MEMORANDUM

To: FILE
From: Shukria Wiar
Subject: Application ID: 2013-058
Date: 3/21/2013

Comments Submitted by: Shukria Wiar/Planning on 3/21/2013

**C-100**

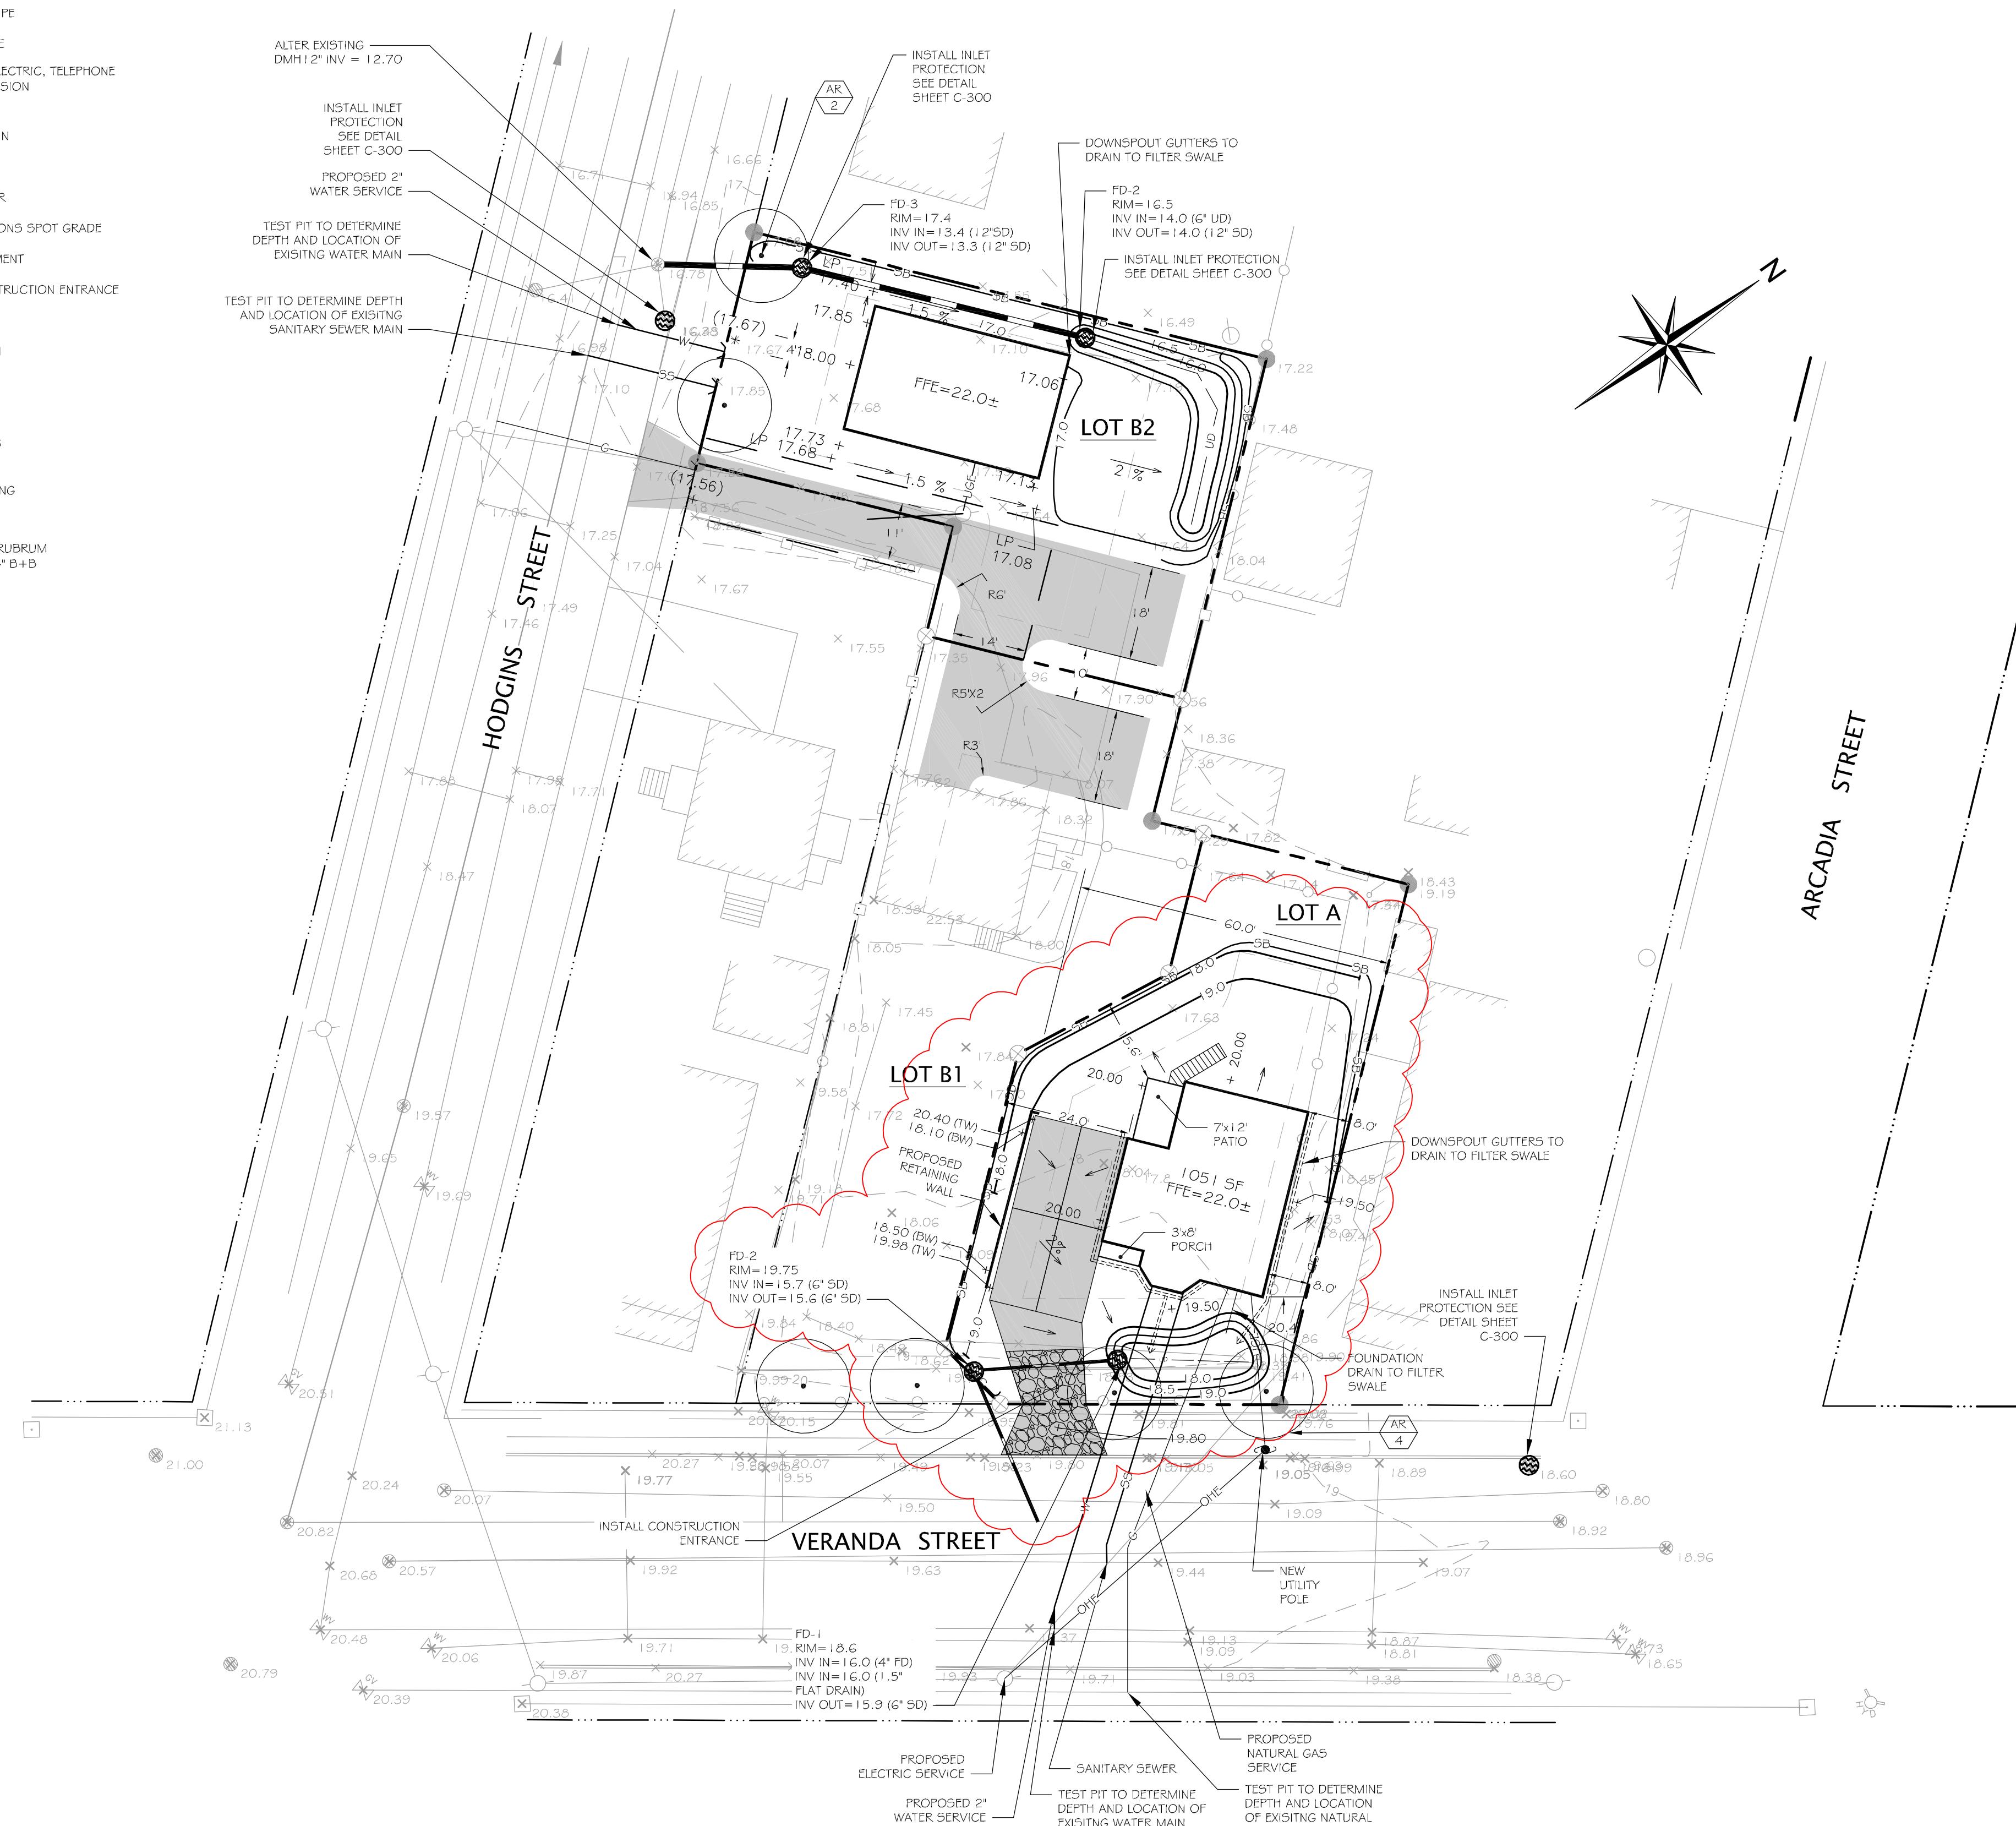
3. The plan is showing overhead utilities for the two proposed houses, all utility lines must be placed underground.

4. The utilities plan shows a sidewalk along the frontage on Hodgins Street but the cover letter talks about a waiver of the sidewalk. If the applicant is requesting a waiver, the applicant will need to meet criteria for it. The sidewalk criteria are attached.

6. The Grading Plan will need to show the grading around the proposed houses so that staff can review how the stormwater will be drained into the rain gardens. Please provide more details on the grading.

a) Basic Standards: Plans, notes, and details have been provided to address erosion and sediment control requirements, inspection and maintenance requirements, and good housekeeping practices in general accordance with Appendix A, B, & C of MaineDEP Chapter 500; however, the proposed locations for catch basin inlet protection should be noted on the site plan.

4) Stormdrain pipes are not permitted to be connected into City of Portland catch basins per the City of Portland Technical Manual, Section 2.7.8. The Applicant should propose an alternate means of connecting Lot B2 to Hodgins Street.

5) The Applicant should provide more detailed site grading and surface drainage information on the Site Utilities and Grading Plan (C-100), including elaborating on the requirement for the full roof area to discharge to the soil filter systems to ensure that the future lot designs conform with the permitted stormwater treatment strategy.

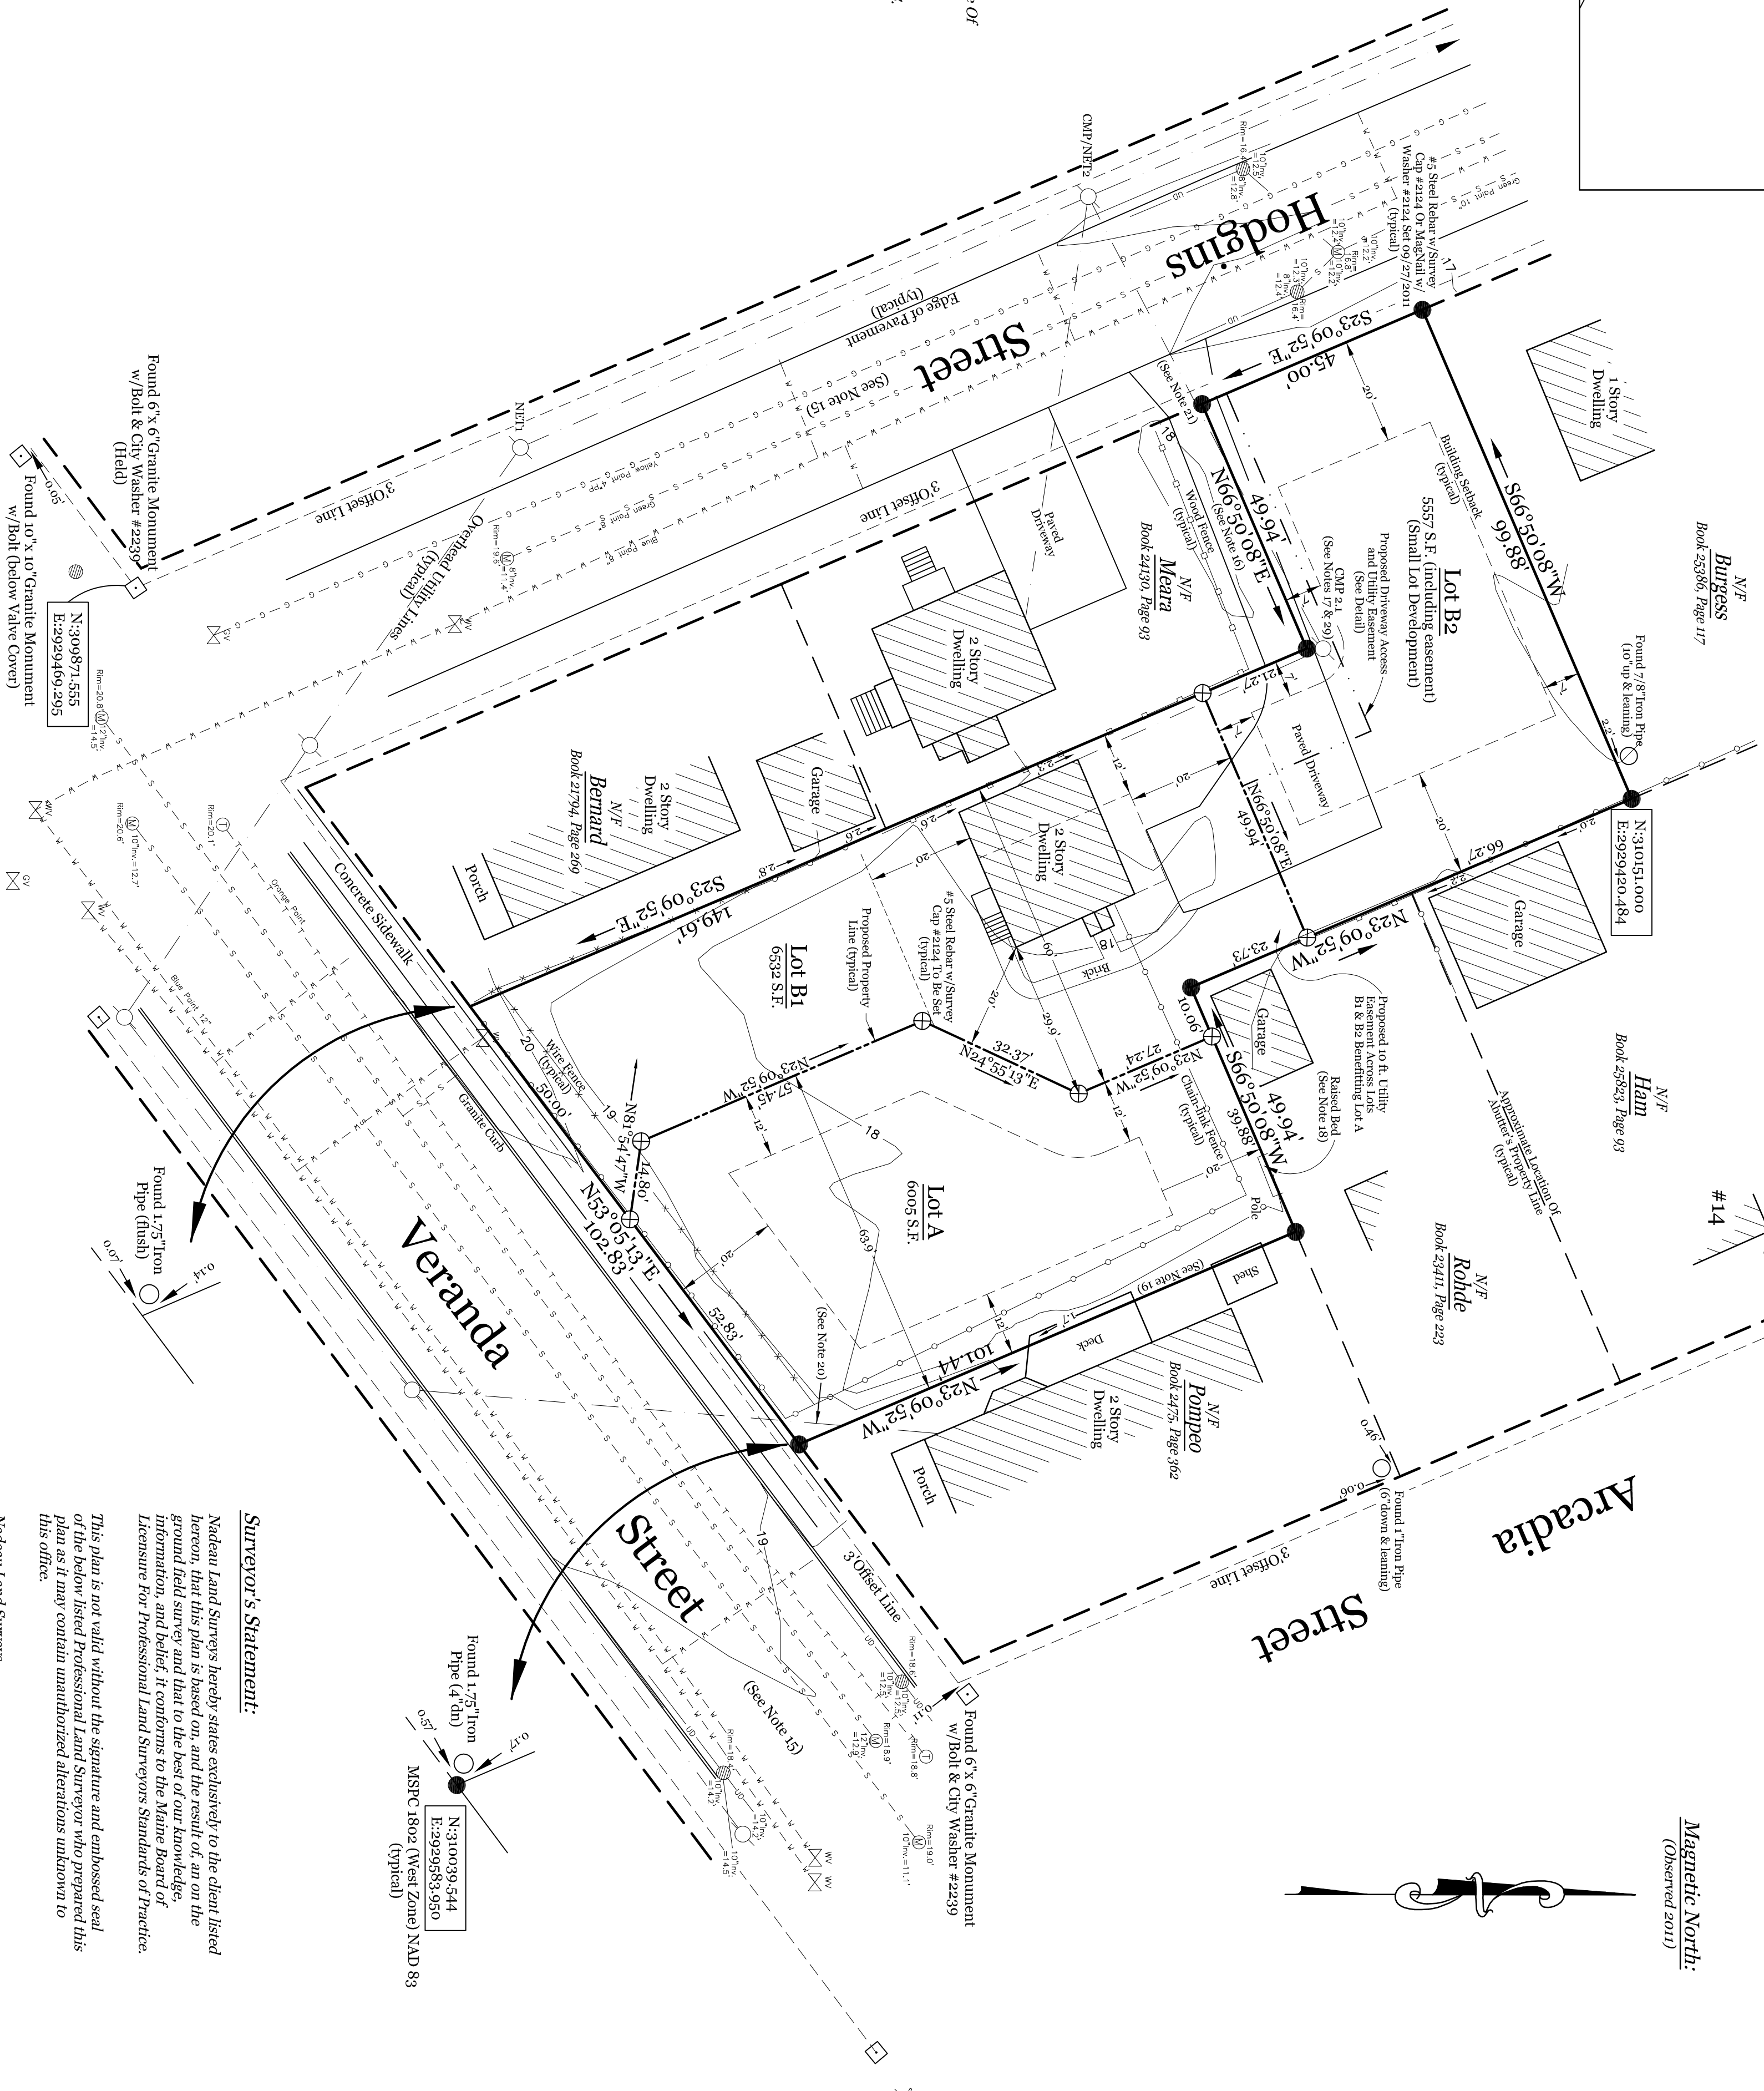
- a. The easement for the shared driveway must be submitted.
- b. For Lot B1, is the CMP pole staying on Lot B2? The plat need to show the utilities for the existing house. Any utilities for the existing house on lots other that it sits on, will need easements. These easements will need to be submitted.

- a. The plat needs to state that Lot B2 is restricted only to a single family lot and Lot A could be a two-family. As currently proposed B1 does not meet zoning requirements for a duplex and therefore has to be single family home.
- b. The applicant is proposing a sidewalk along Hodgins Street, please show on the plat.
- c. The City Surveyor is conducting a review of the plat and comments will be forwarded at later date.

On Lot "A" where the generic building is placed, violates the regular R-5 minimum lot width requirement. The regular R-5 zone requirements state there shall be a minimum of 60 foot for a lot width where a building is placed on a lot. The sketch should be revised to show that all regular R-5 zone requirements can be met. This will help eliminate any misunderstandings from a future purchaser of the land who will want to build on the lot and assume a building can be placed where it can not.

5 BITUMINOUS DRIVEWAY APRON
NOT TO SCALE

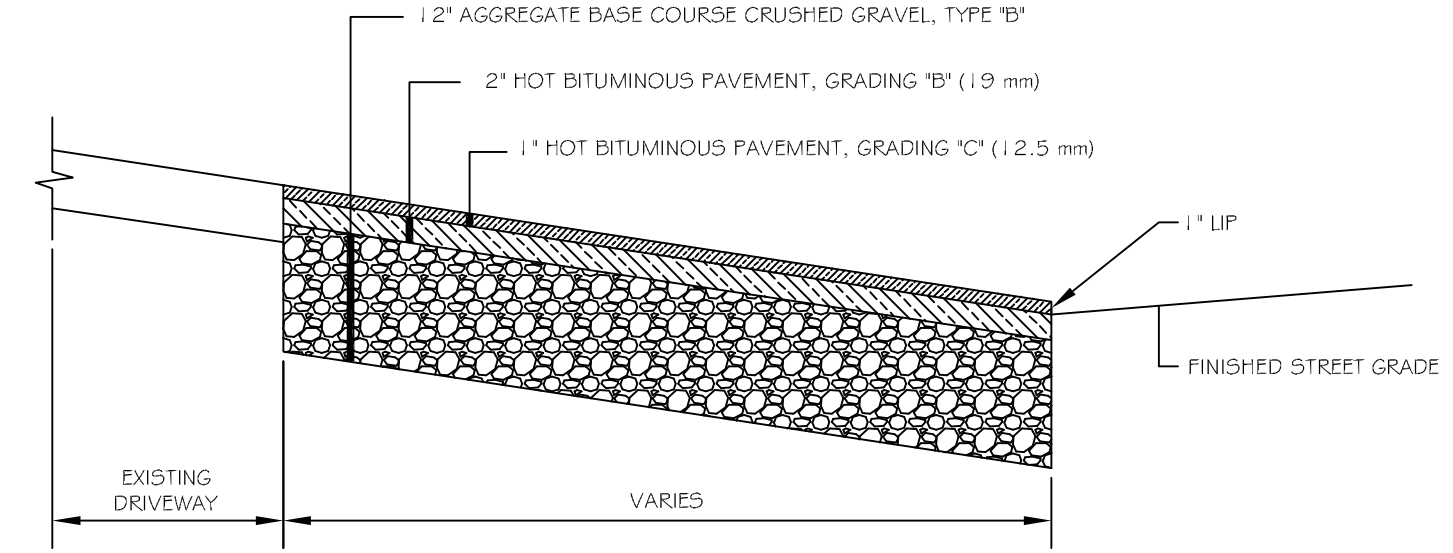
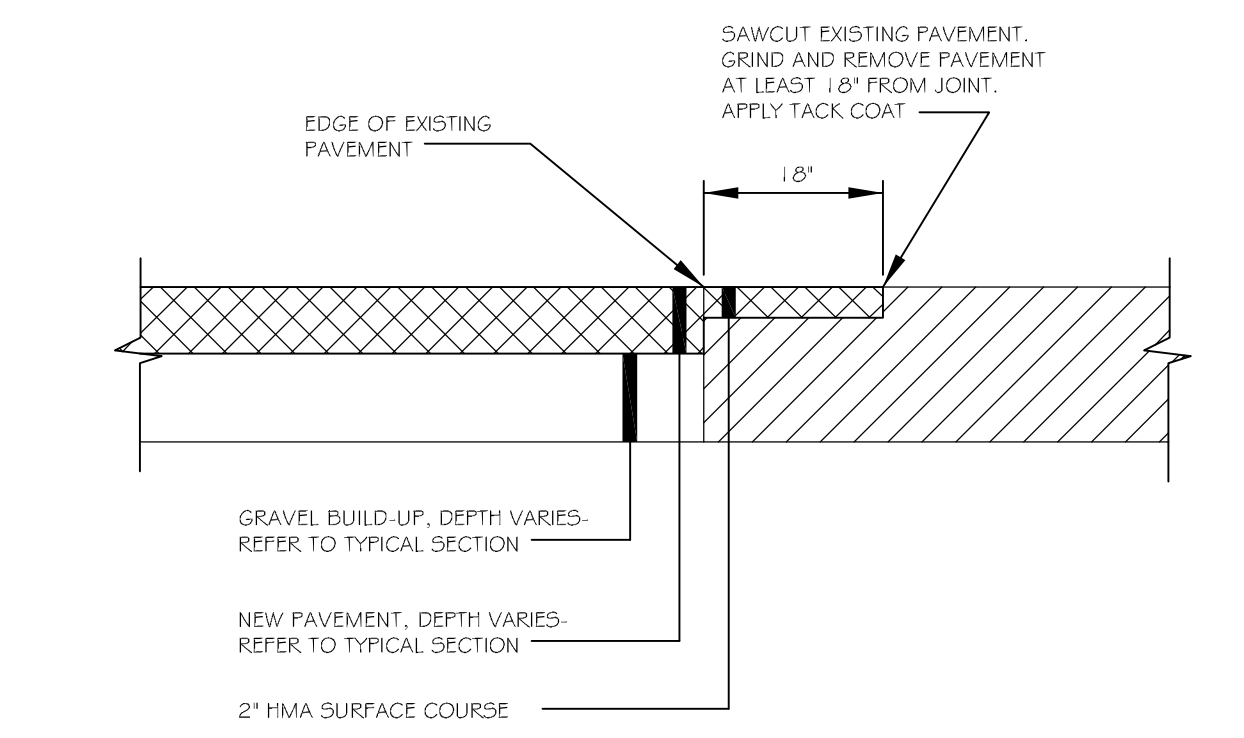
3) The Applicant should provide a Bituminous Driveway Apron Cross-Section Detail in accordance with Figure I-13 of the City of Portland Technical Manual for work within the City Right-of-Way.
